Friday 8 June 2018

Our Reference      160787-01-01L-DD  
Rev 01

**Acoustic Review and Assessment  
Southern Acoustic Barrier  
Mulgrave Substrate Plant, Mulgrave**

**PROPOSED SOUND WALL
ELEVATIONS AND SECTION**

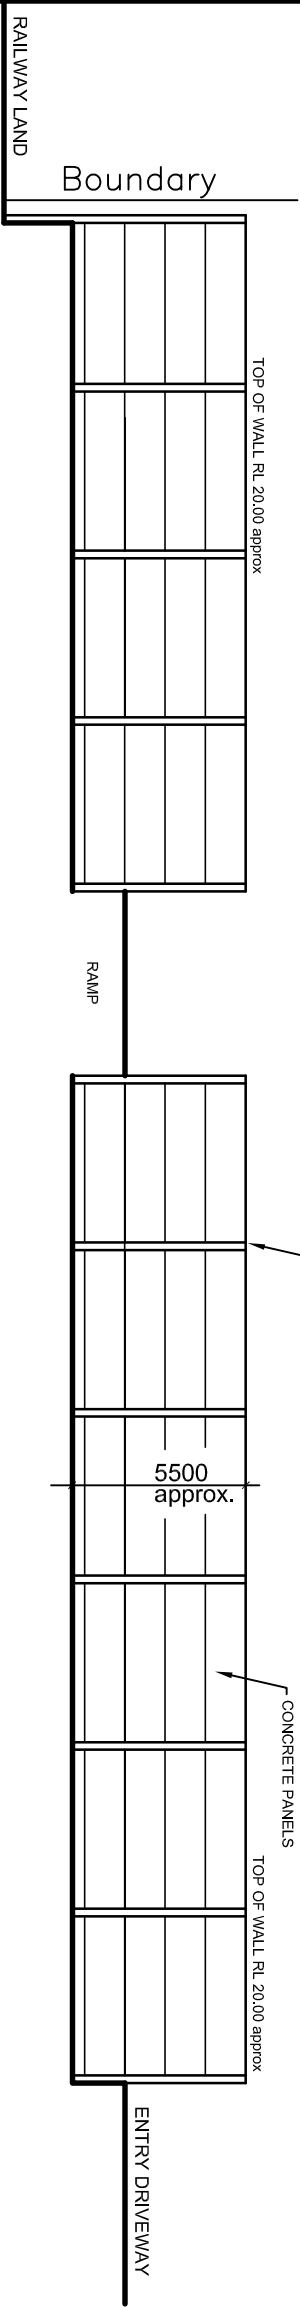
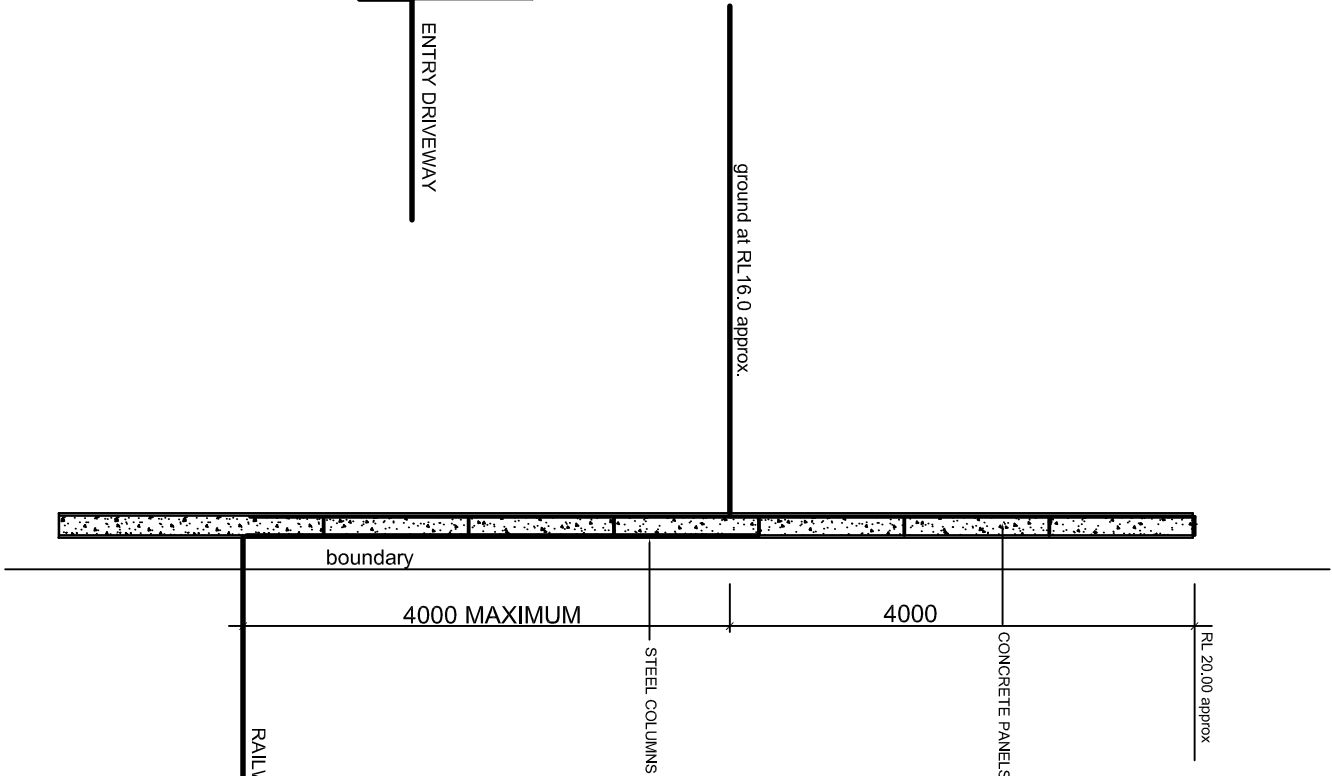
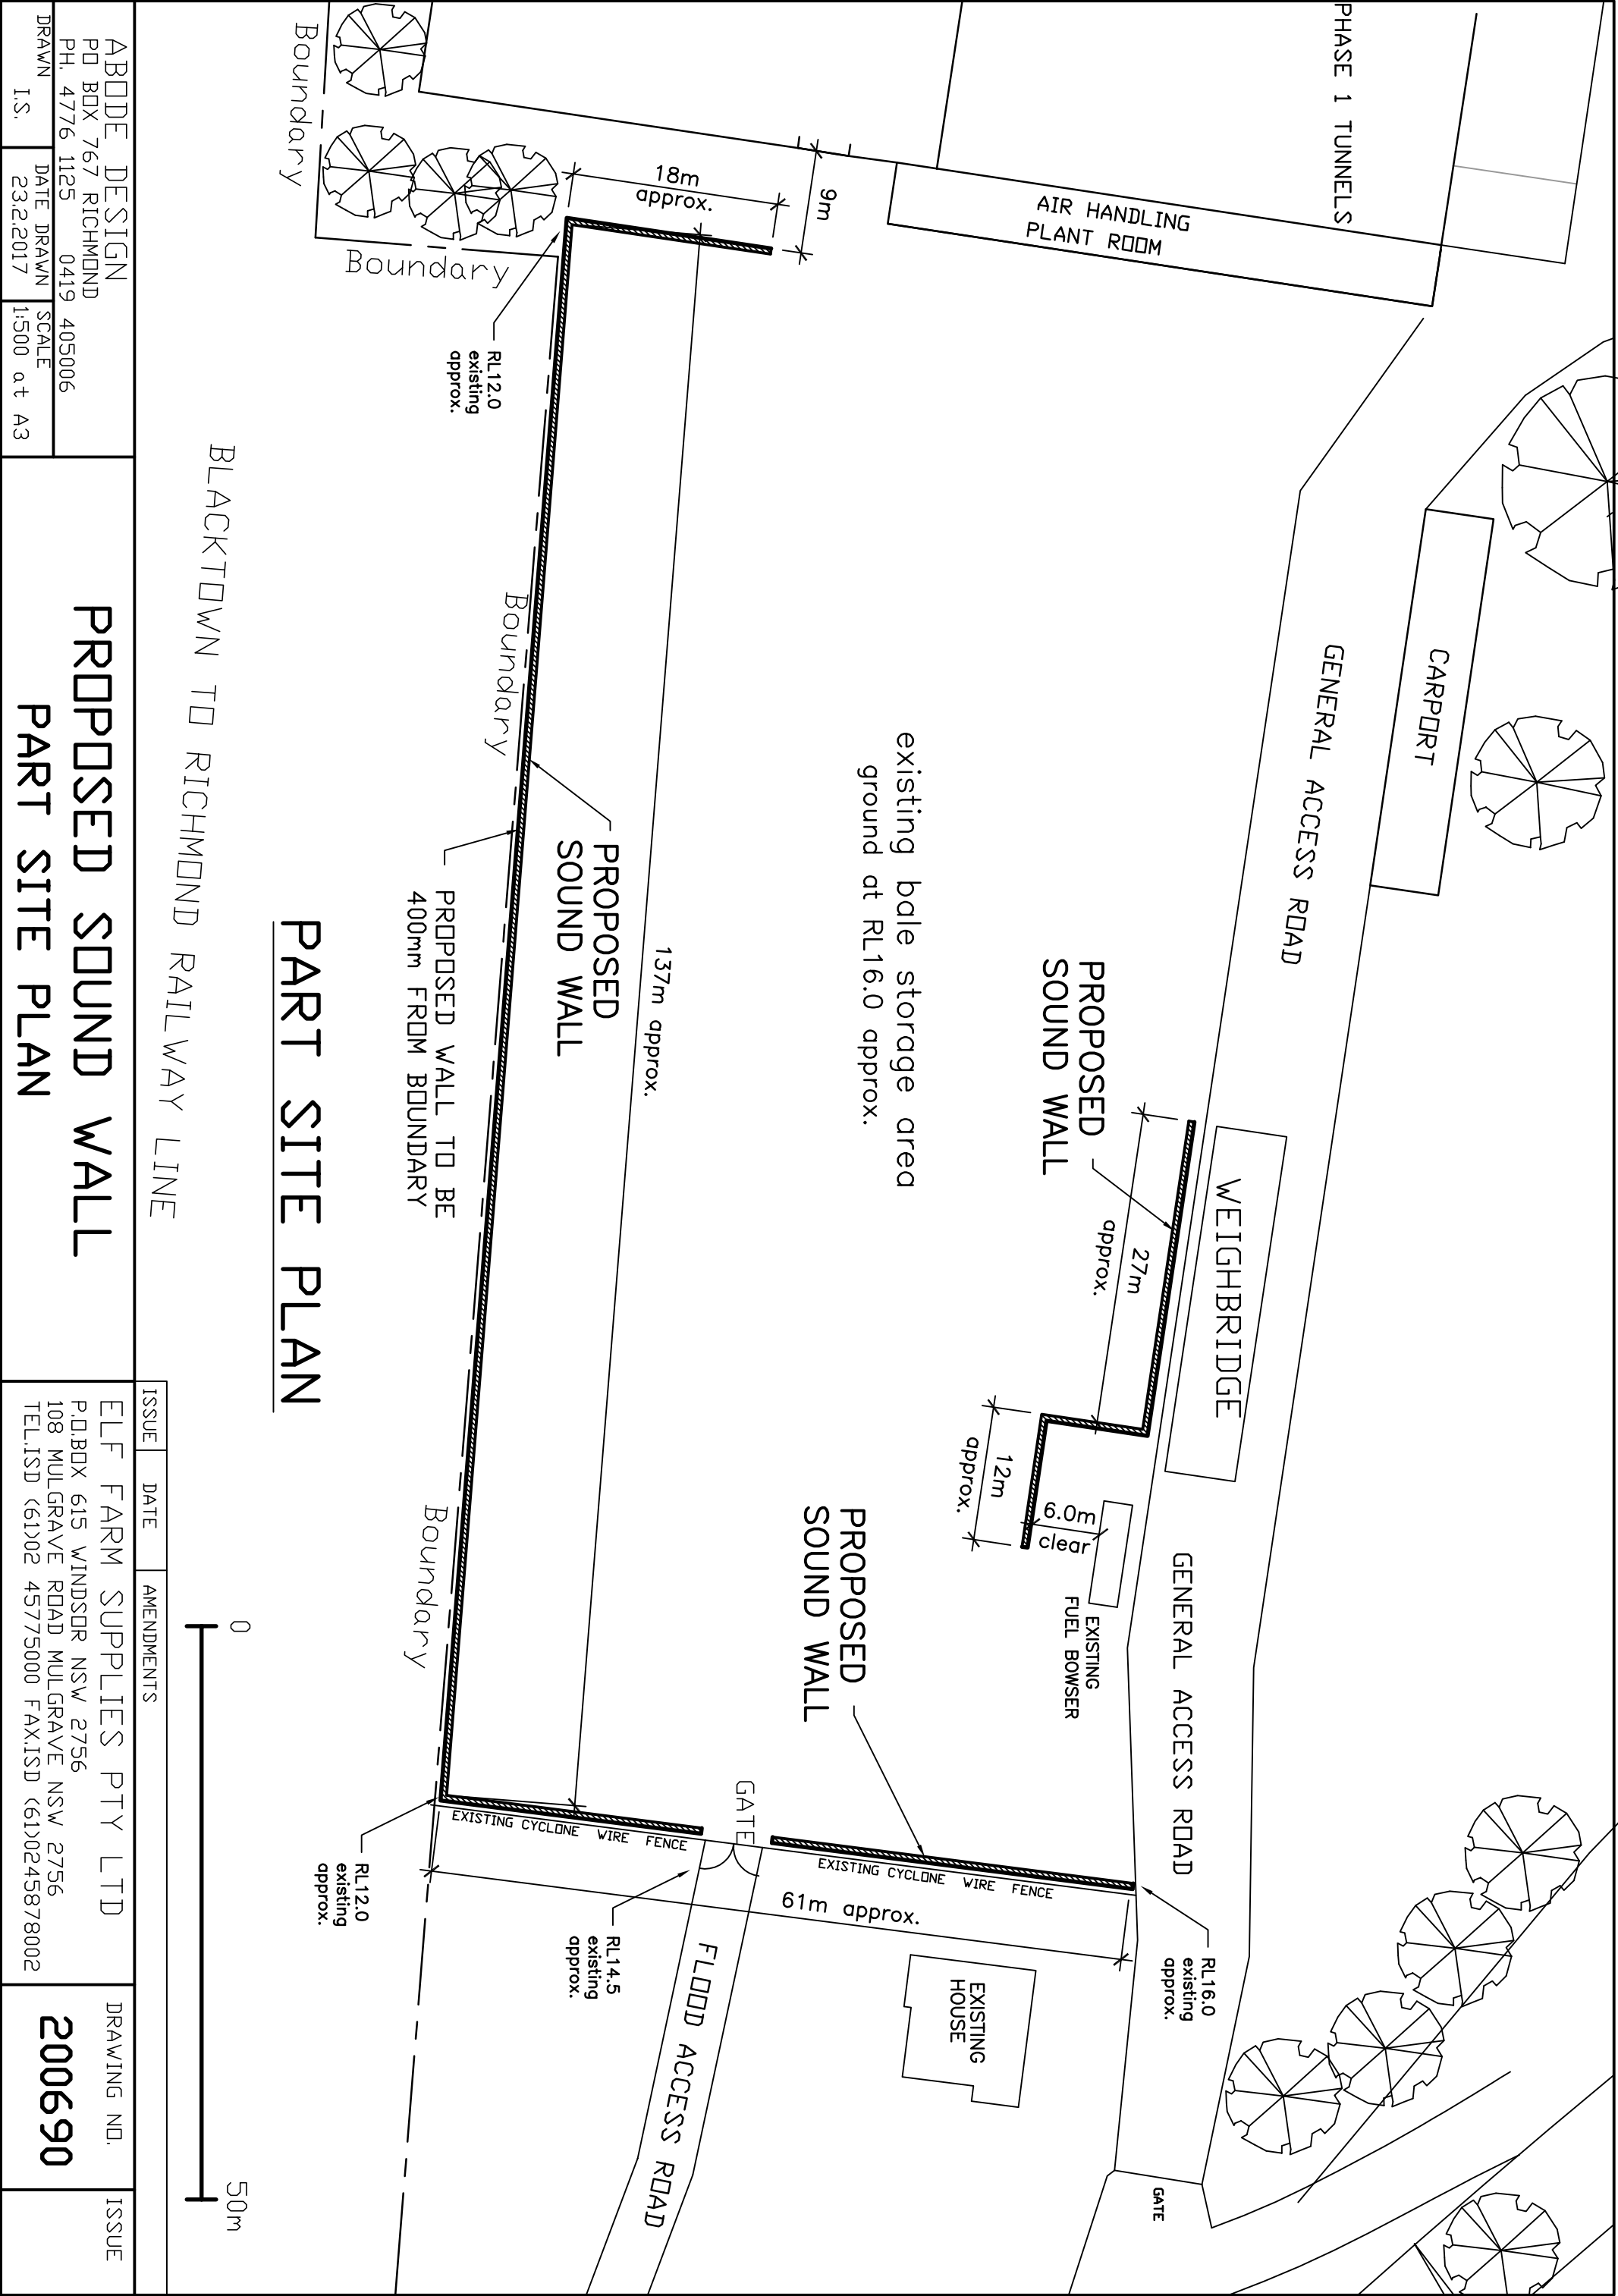
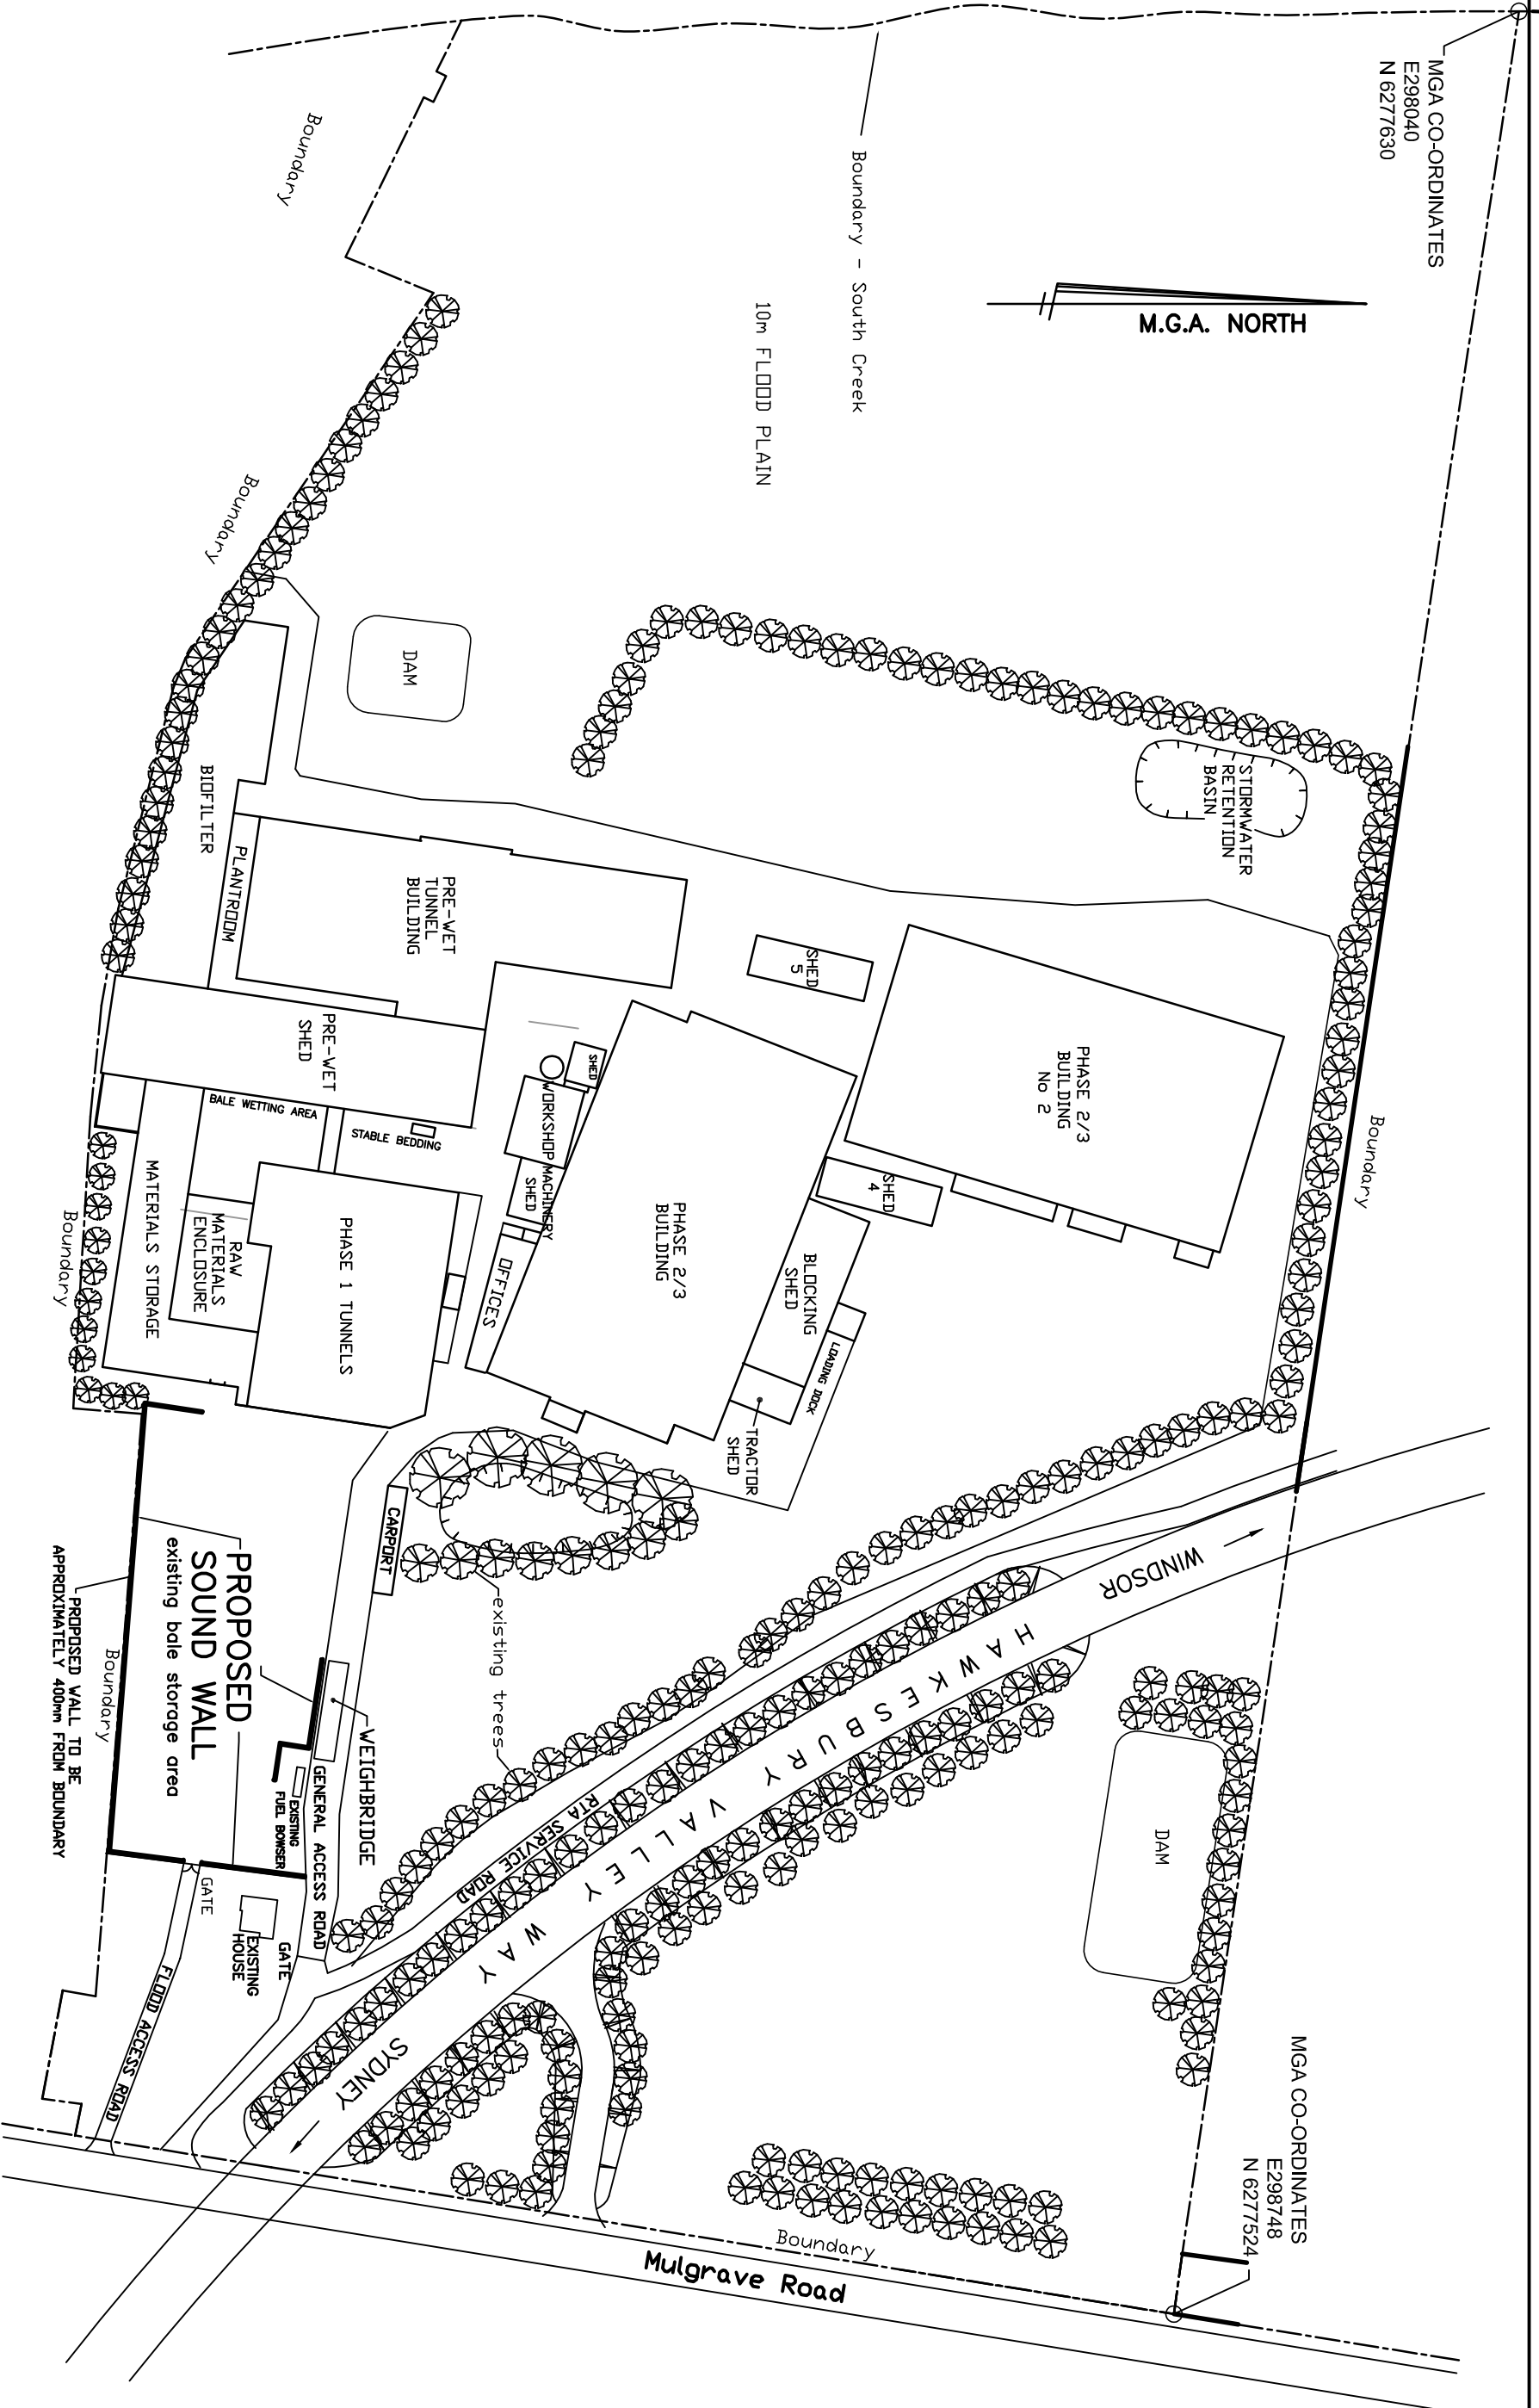
A review of the attenuation provided by a four (4) metre barrier compared to a seven (7) metre barrier for the closest receivers confirmed a difference of 4dB. The lower noise attenuation provided by the reduced barrier height is more than compensated by the lower source noise level from the current front end loader operating in this area.

In light of the lower front end loader source noise level, Acoustic Consulting Engineers Pty Ltd has considered a nominal acoustic barrier height of four (4) metres above finished bale storage level (RL16) resulting in an acoustic barrier along the southern and eastern sides of the bale storage area with a nominal RL20.

Considering distance separation (FEL at closest and farthest positions in storage area) and shielding provided by proposed high acoustic barrier (four (4) metres high)), the predicted noise level contributions from the front end loader to the affected receiver locations are:

The original seven (7) metre high barrier as documented on Design Drawing No.: 200608 Issue J was intended to provide structural support to the bale wetting boom equipment. The height of this wall was not driven by acoustic requirements, and the concept wall height was simply adopted in the 2010 and 2014 noise assessments. As the eastern external bale wetting area identified in DWG 200608 J is no longer required, the height of the acoustic wall to the south and east of the bale storage area could be amended.

- bale unloading, storage and transfer of bales within the bale storage area utilise the existing Hyundai HL757-9 and Liebherr 550 front end loaders, or equivalent loaders with an operating sound power level of not more than 98dB(A);
- existing reversing beepers on loaders be replaced with broad band level varying 'quacker' reversing alarms; and
- acoustic wall (Hebel, precast concrete or equivalent) be constructed to the south (adjacent southern boundary) and east edge of the bale storage area not less than four (4) metres above finished ground level of area (nominally RL16) resulting in a nominal barrier height of RL20.
